KIRKLEES METROPOLITAN COUNCIL INVESTMENT & REGENERATION SERVICE

DELEGATED DECISION TO DETERMINE PLANNING APPLICATIONS

Reference No:	2025/62/91666/W
Site Address:	65, Norman Road, Birkby, Huddersfield, HD2 2UD
Description:	Demolition of existing single storey rear extension and erection of replacement single storey rear extension (within a Conservation Area)
Recommending Officer:	Joshua Merriman

Officer Report – 2025/91666

CLIENT	Mr Naeem		
ADDRESS	65 Norman Road Birkby, HD2 2UD		
PROJECT	Single Storey Rear Extension		
DRAWING	Existing and Prop Layout and Elevations		
DRAWN	UH	DATE	Feb 25
DWG No.	2524/01	SCALE	1.100@A1
STATUS	CONCEPT

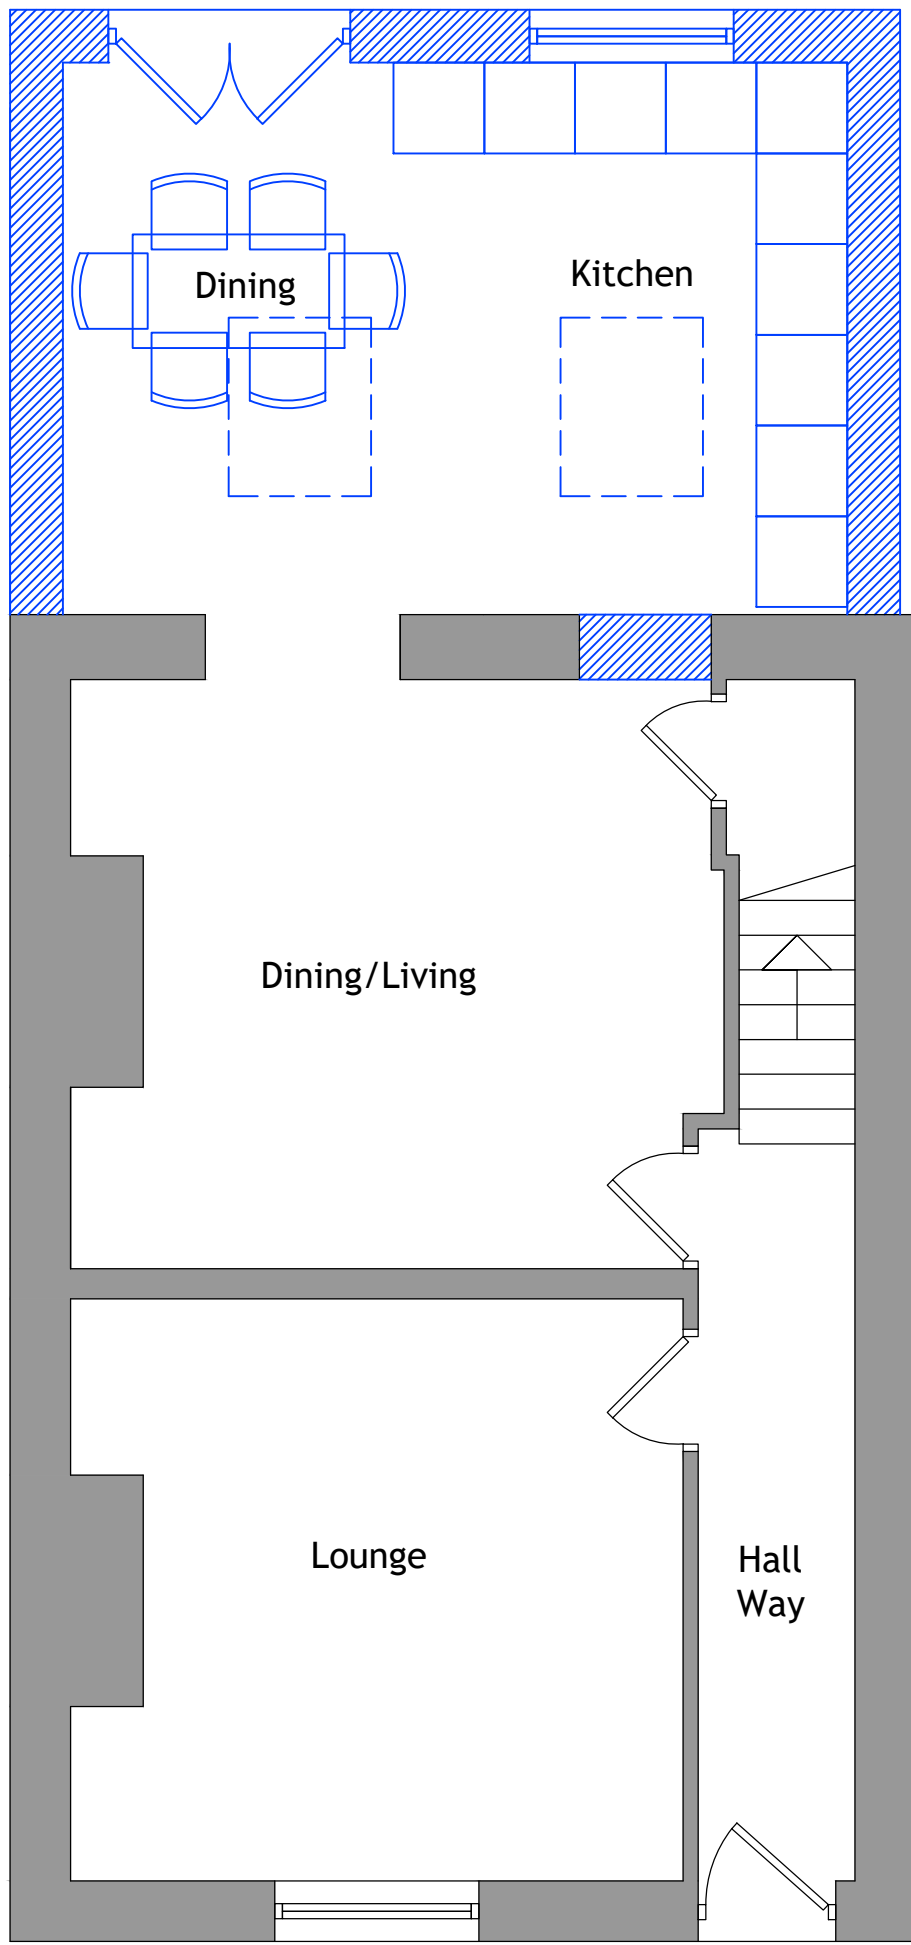
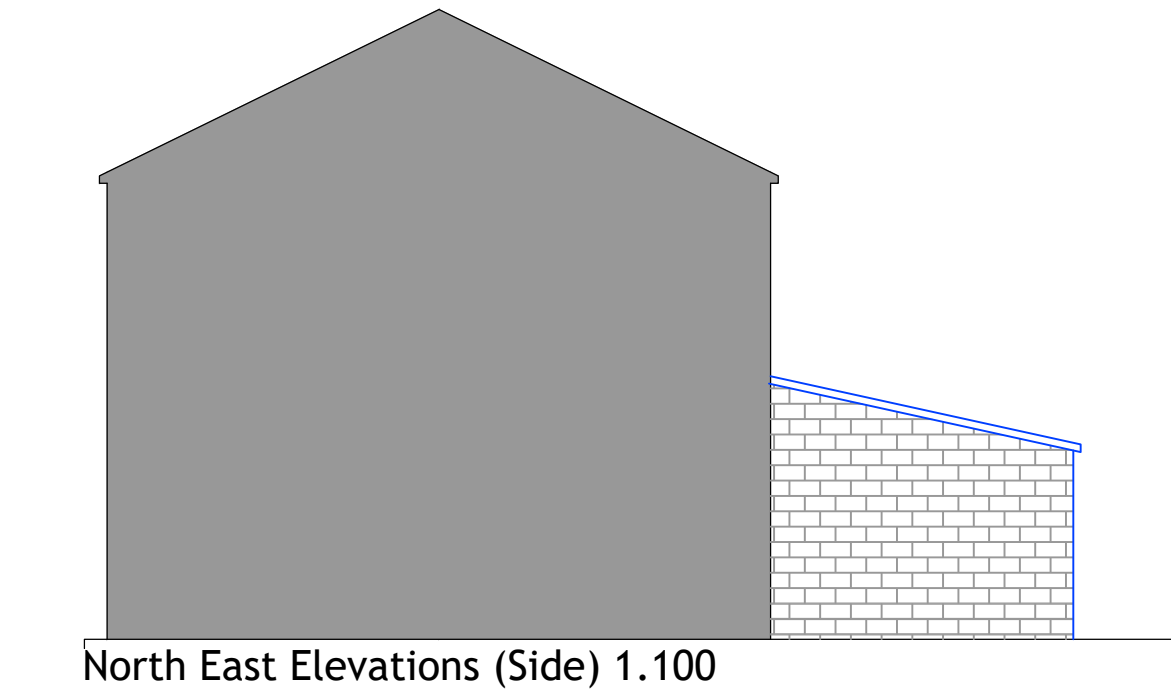
The case officer sought it necessary to request a reduction in the projection of the rear extension to reduce the impacts on residential amenity of adjoined properties. Following this, the applicant submitted amended plans reducing the projection of the extension to 3.5m, which no longer cut the 45-degree angle from rear windows in the neighbouring property, and therefore is considered acceptable in this case.

Despite this, the extension is proposed to project 3.5m from the rear elevation of the original building, exceeding the 3m allocation for terraced properties in the House Extensions and Alterations SPD, however this was requested by the case officer. The initially proposed plans detailed the extension having a 4m projection, which was considered to have a significant impact upon the residential amenity of neighbouring properties, however, if the projection was reduced to 3.5m, this would reduce the impacts on neighboring dwellings as the 45-degree angle to windows in the rear elevation would no longer be cut. As a result, the projection distance of 3.5m is considered acceptable in this instance.

05/08/2025 – Existing and Proposed Layout and Elevations 2524/01A
